April 16, 2018
15056

Response to City Review Comments
Portland Public Works Building Expansion

We have reviewed the comments from the April 11th, 2018 meeting regarding City review comments for the Portland Public Works Building Expansion at 250 Canco Road and offer the below responses in the appropriate order.

**PEDESTRIAN WALK W/ CURB**

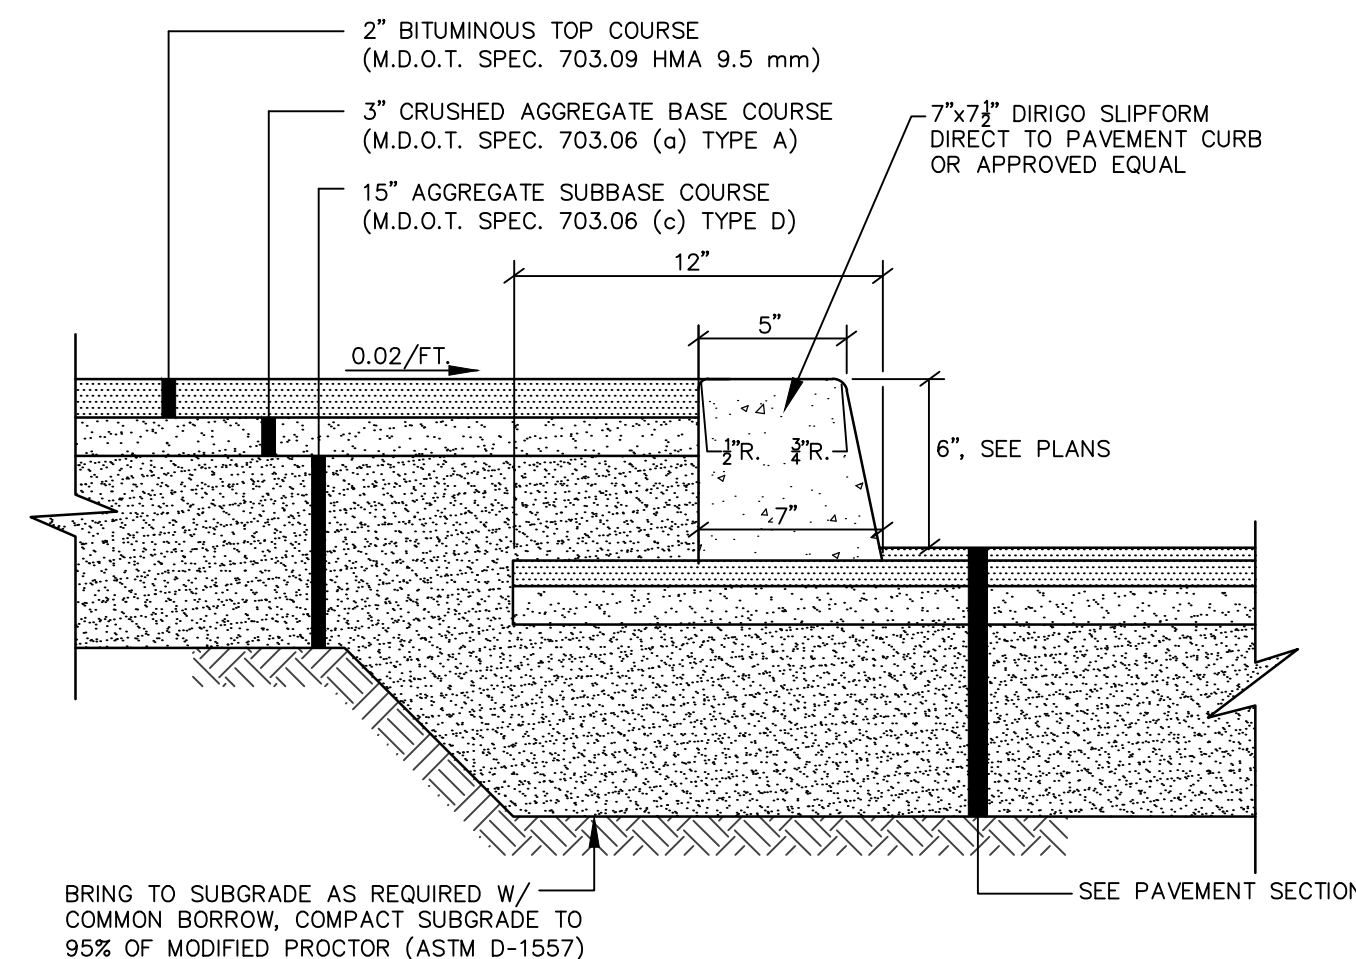
- **The City has requested that the applicant create a connection from the walkway on the northeastern side of the existing building, which serves a side door that is used as the primary entrance for visitors, to the sidewalk on Canco Road.**

We have provided a sidewalk that connects the existing walkway to the existing sidewalk along Canco Road. This change is reflected in the updated plan set. Please see attachments.
